Re: 45 Northaw Road East, Cuffley EN6 4LU –

Ref. No: 6/2015/2223/HOUSE

Re: Our Complaint to Enforcement- Breach of Planning Application

Side Elevation Proposed

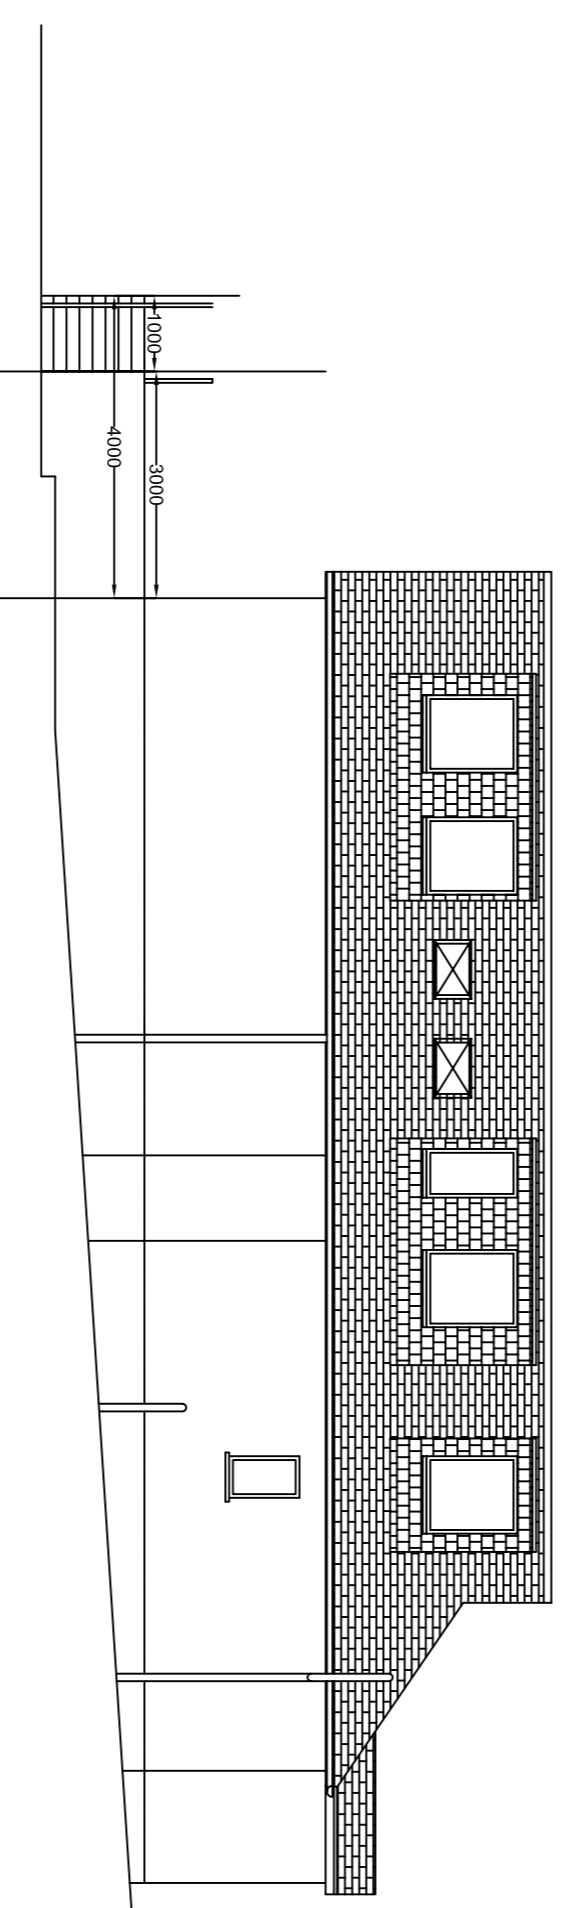
Mrs Charles was contacted by telephone on 17th November 2015 and later by letter dated 20th November 2015 (copy enclosed requiring that theDormer Windows should be scaled back and fitted with fixed obscure glass....).

The Owners (of No. 45) do not live at the property. The Architect, Mr Michael David has not confirmed to us if the Owners have agreed to obscure glazing of their dormer windows on the first floor, following the Council's request.

Front Elevation Proposed

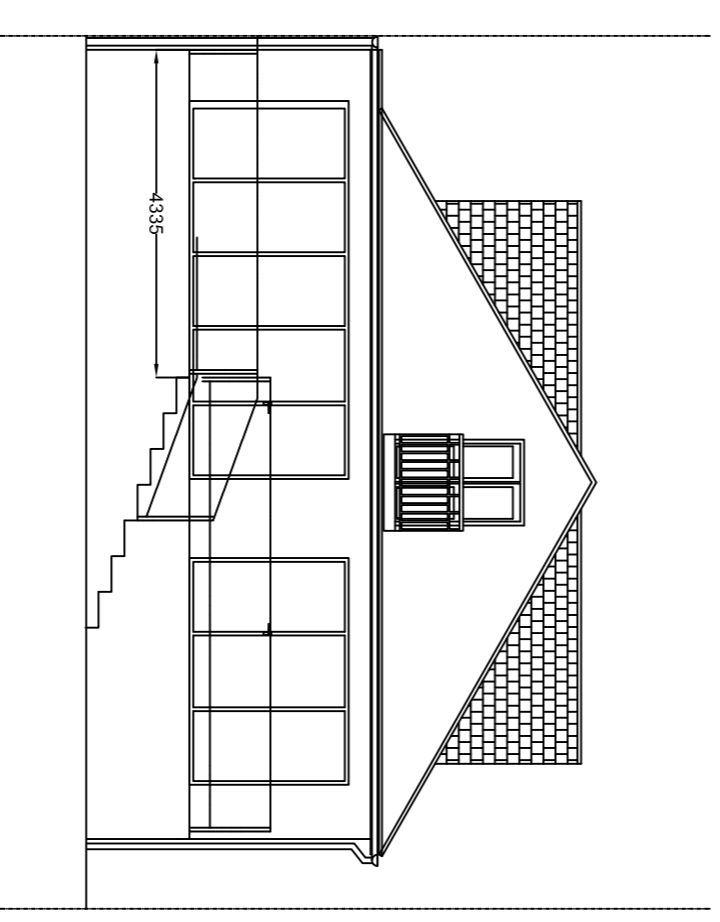
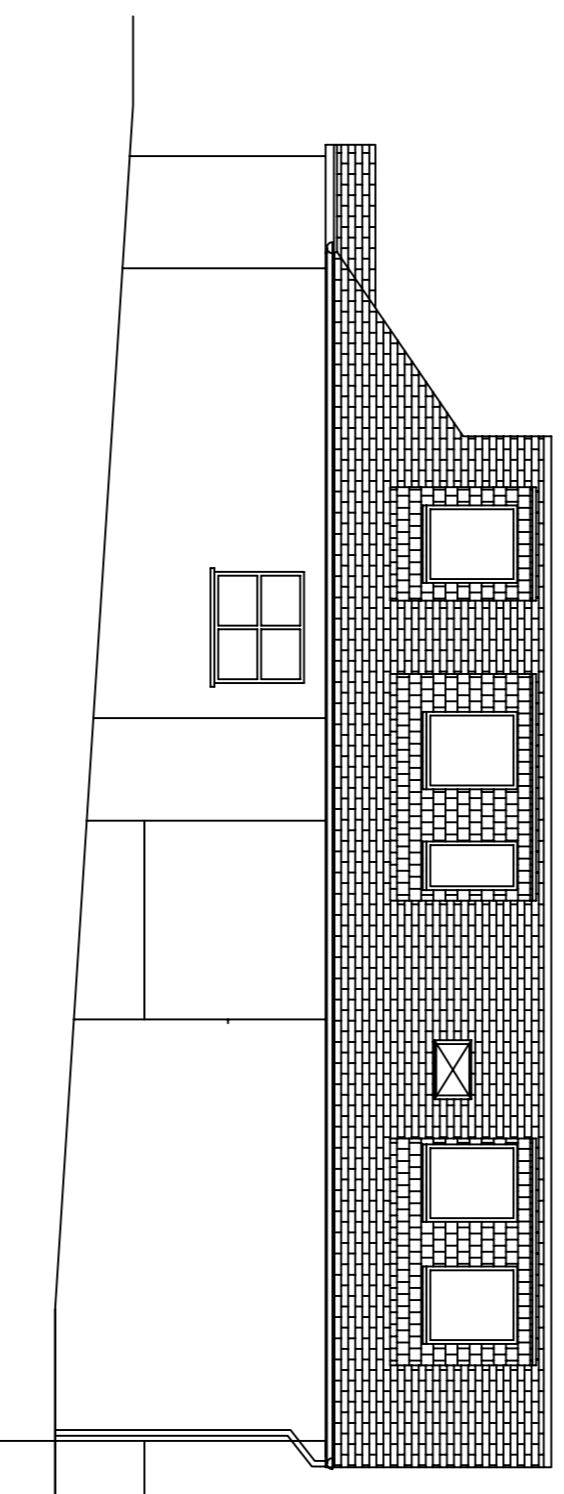
We have photographic evidence that the eaves height has been raised and this has been confirmed by our Party Wall surveyor. This is in breach of Planning and must be acted on immediately.

Further the size of the top hat surrounding the roof has been constructed to allow for the raising of the ridge height whilst obscuring the construction. Please confirm how the ridge height post building work can be confirmed to be the same height as present. It is rightly feared that this will be another breach of Planning.
